Re: PA22-024- Marysville 44th PRD – Technical Review 1
 7315 / 7417 44th St NE – APN(s) 30053500303700 / 30053500303600

After preliminary review of the above referenced proposal, the Planning Division has the following comment(s):

DRAWING: C8
SHEET: 8 OF 8

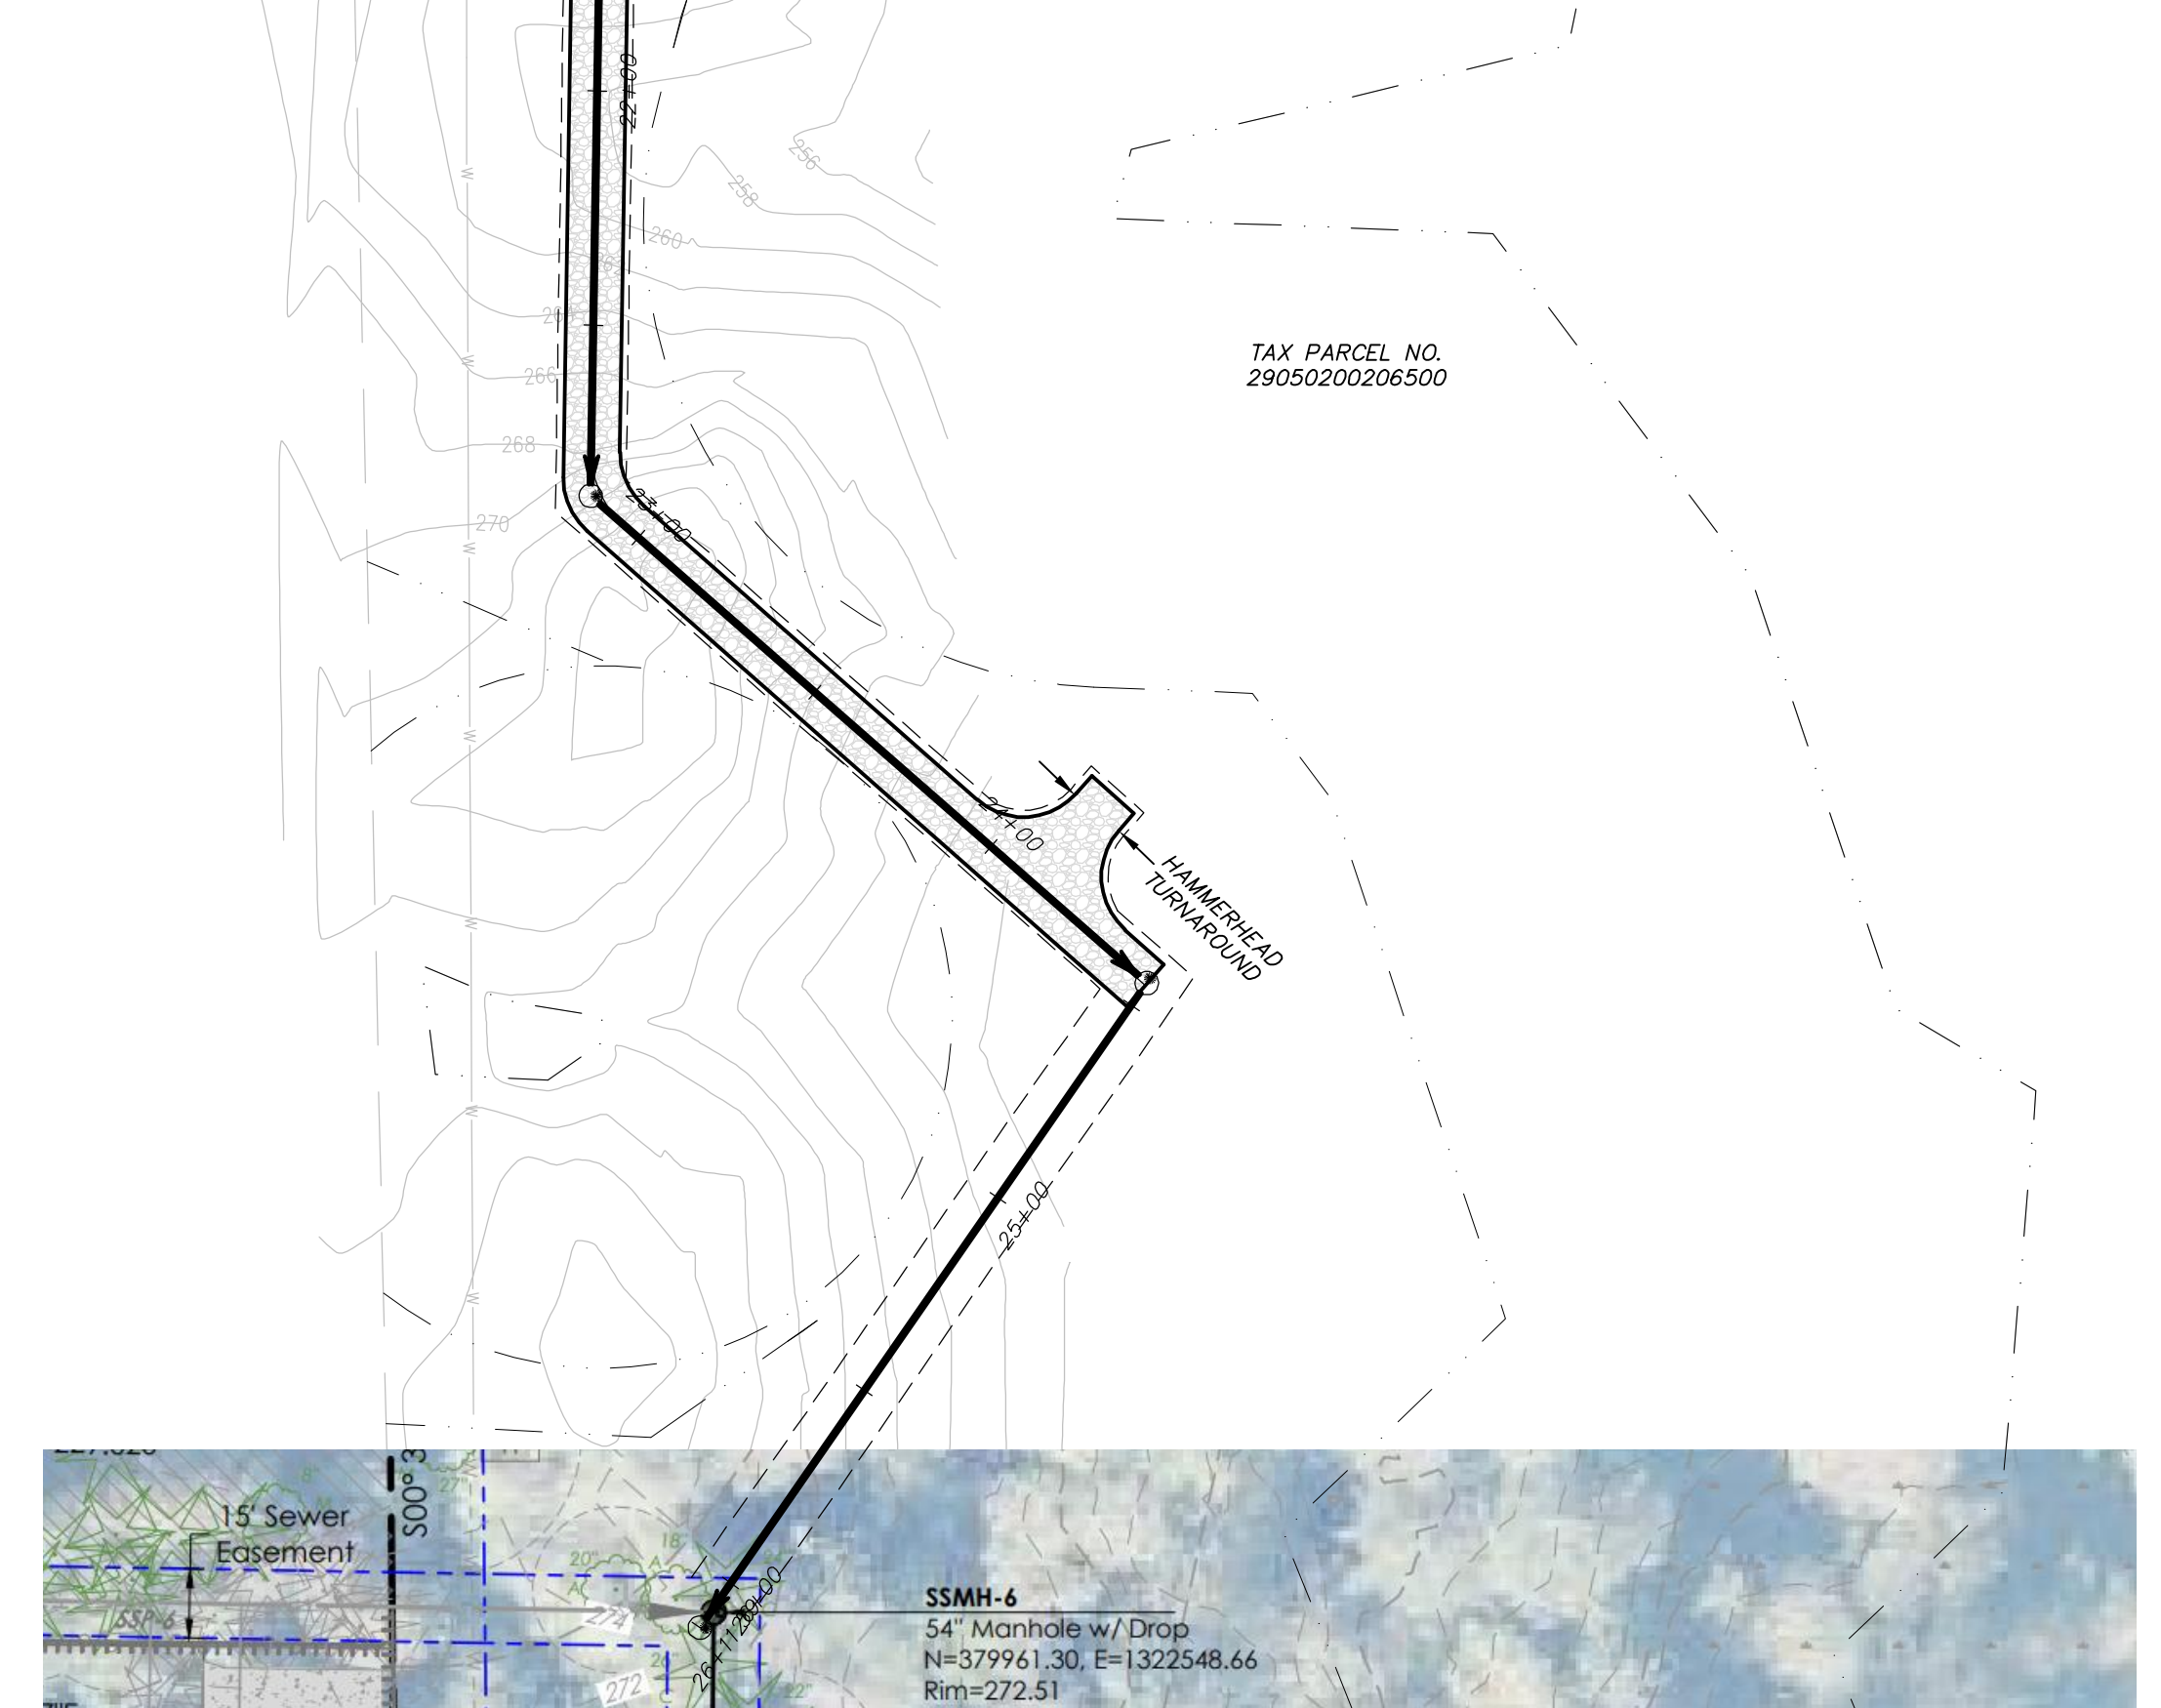
2. The sewer route is shown on sheet 8 of the civil plans (Conceptual Sewer Plan) but the sewer depths are not shown (or at least I cannot determine them). Although not needed for this development, the sewer continues east on 44th St past the connection point to the east edge of the property. Presumably, this is to allow future connections to the northeast and southeast to use the sewer line. **Will the eastern terminus of the sewer line be placed deep enough to service other properties in this area?**

Based on the slope of 44th St, it looks like eastern inlet to the sewer could be as much as 15' deeper (from the road surface) than the connection point for the new development on 44th St. The deeper this inlet is the more area this sewer will service. If it is allowed to be the minimum depth it won't service much of the area but if it is put as deep as possible it will likely service most of it.

LANDSCAPE PLAN

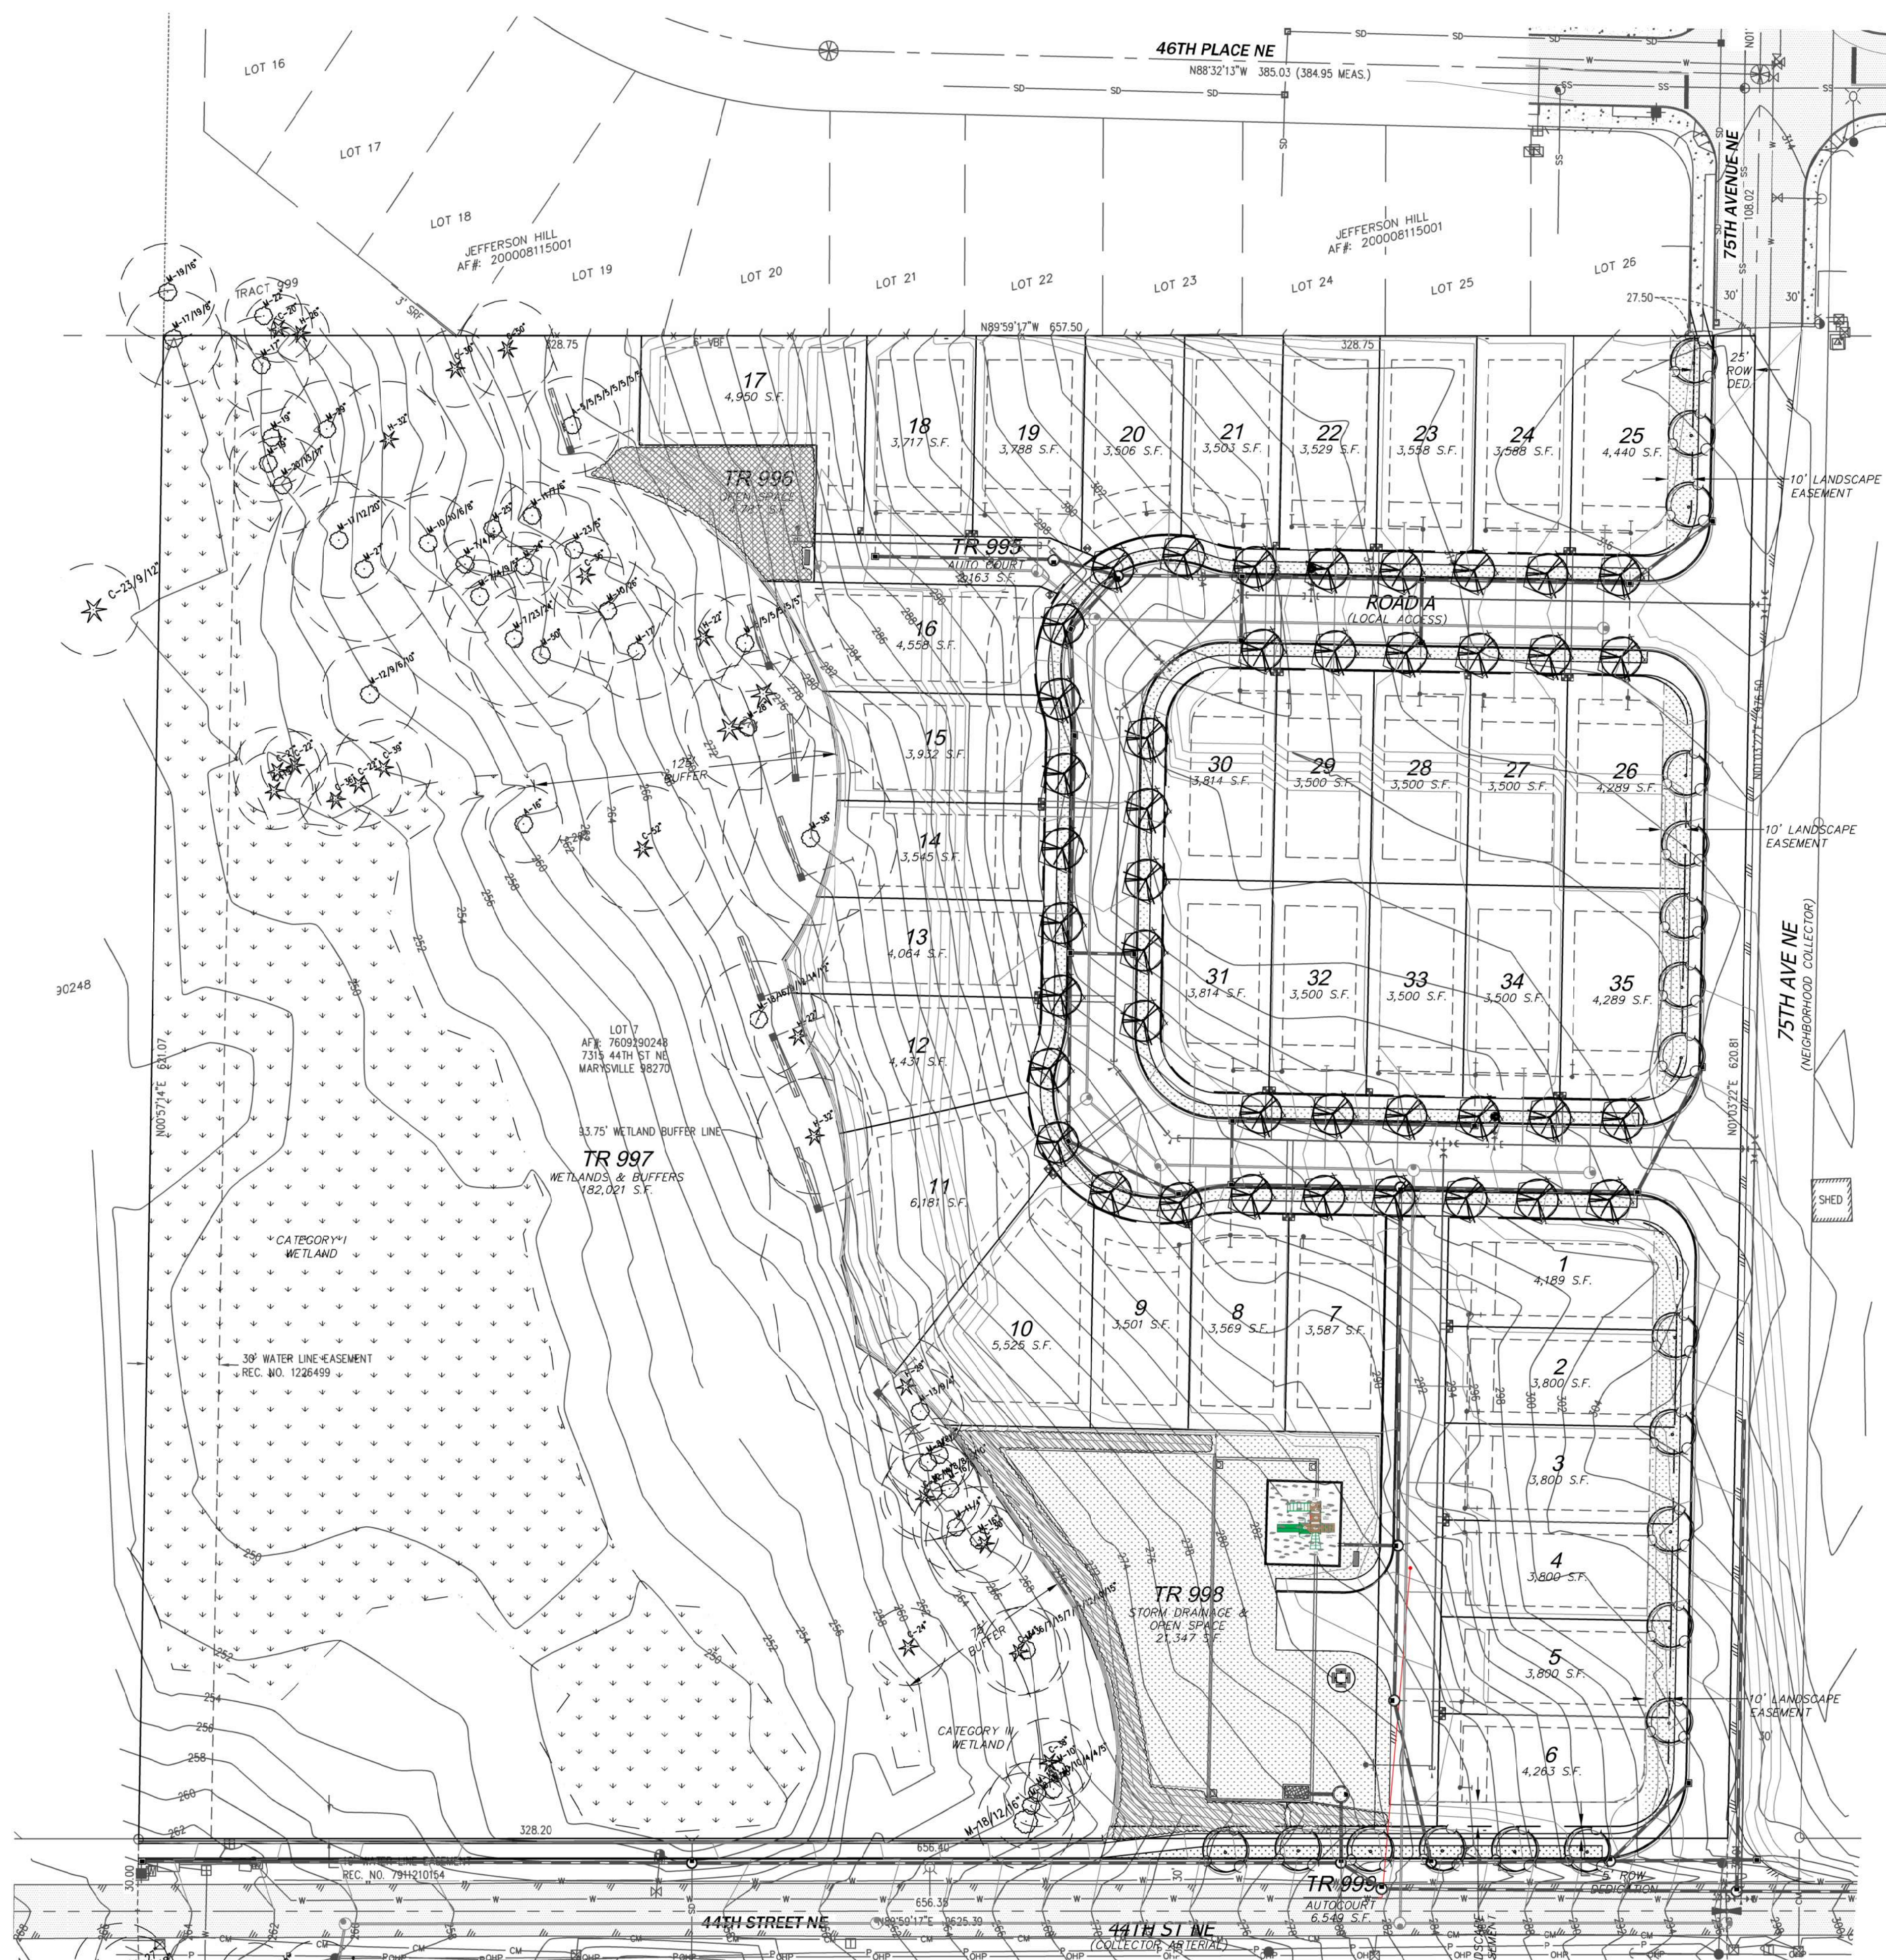
15. Based on the provided plans, Tract 996 is to be completely landscaped with Salal.
As proposed, this tract would not meet the open space requirements of MMC 22G.080.100(4), specifically: *(a) be of a grade and surface suitable for recreation.*

- 16.2. Typical side view of perimeter landscape areas, specifically the proposed 10 ft. landscape easements.
 - 16.3. Location of precast vault lids need to be shown as well as proposed access to said lids.

- 16.4. Provide details for the proposed open space amenities. Additional comments related to the open space amenities will be provided by Marysville Parks, Cultural and Recreation Department.

- 16.5. Provide detailed landscaping planting plans for the proposed open spaces Tracts 996 and 998.
